Your ref: 03.2024.0518
Our ref: 03.2024.0518
Date: 08.07.2024

Planning Application No: 3/2024/0518

Proposal: Proposed demolition of existing conservatory and outbuilding and construction of twostorey

Location: 18 Queensway Waddington BB7 3HL

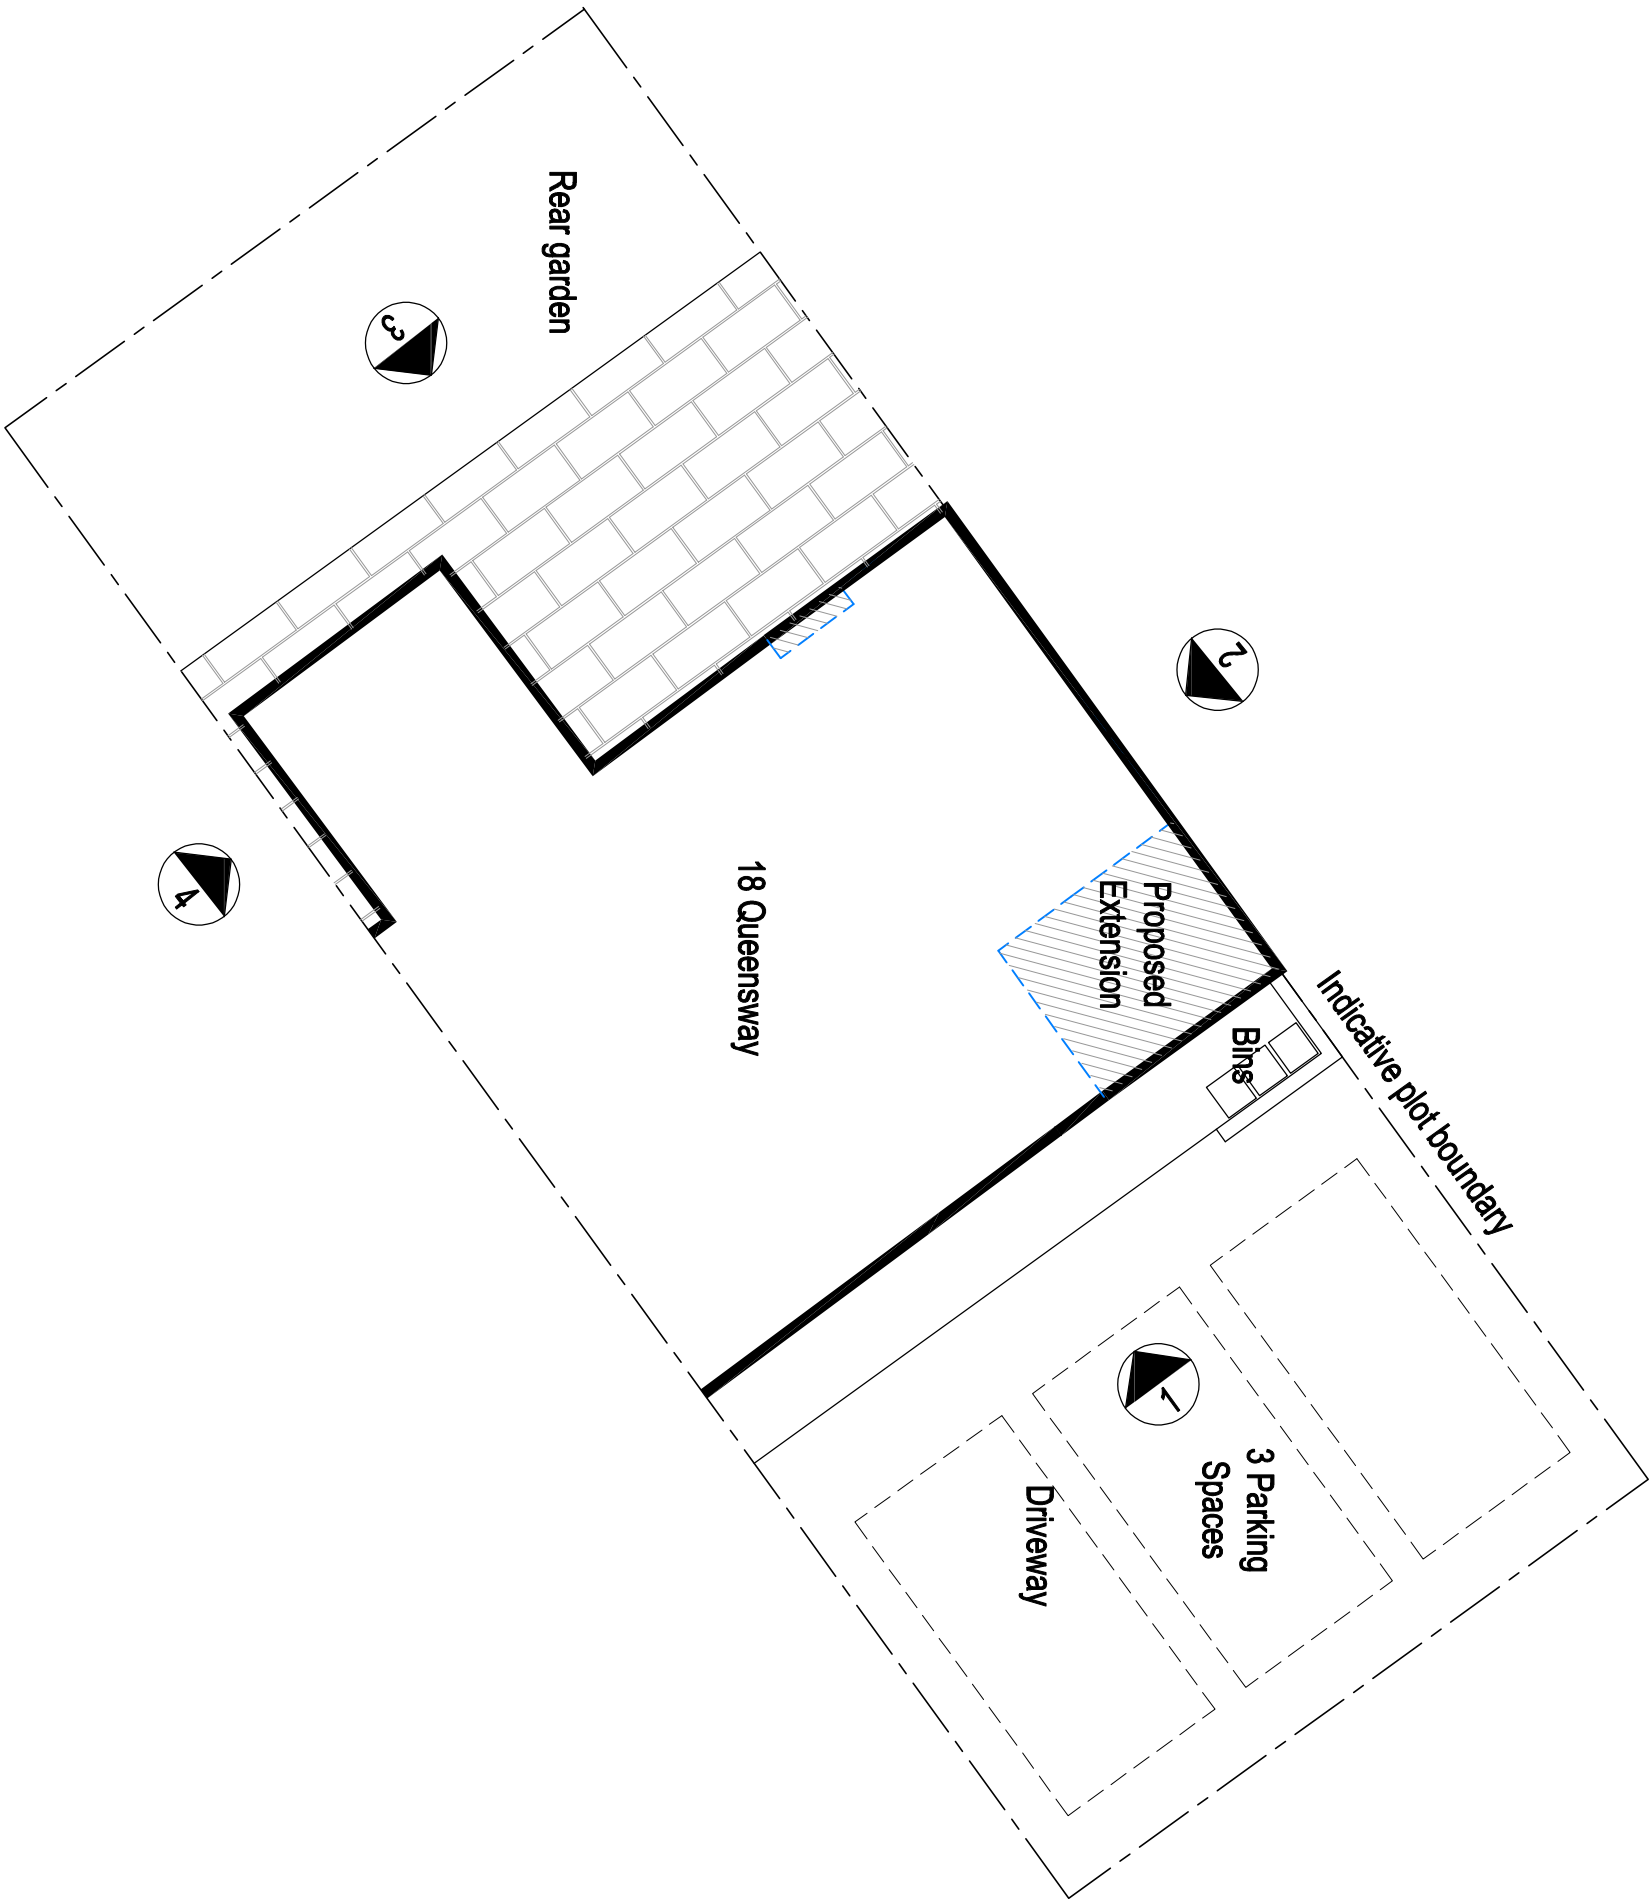
Having considered the information submitted, the proposal increases the number of parking spaces from the current 2 to a proposed 3 (Ref. Drawing 24.026 PL05) as required by parking standards for this size of proposal. The proposal includes the widening of the driveway to ensure the off road parking spaces requirement can be met within the curtilage of the property. Therefore, there is no objection to the proposal subject to the following conditions:

- The parking areas must be constructed of a bound porous material and created before first occupation up until the lifetime of the dwelling existing in its proposed state. Reason: To ensure that satisfactory parking is provided before the dwelling hereby permitted becomes operative.
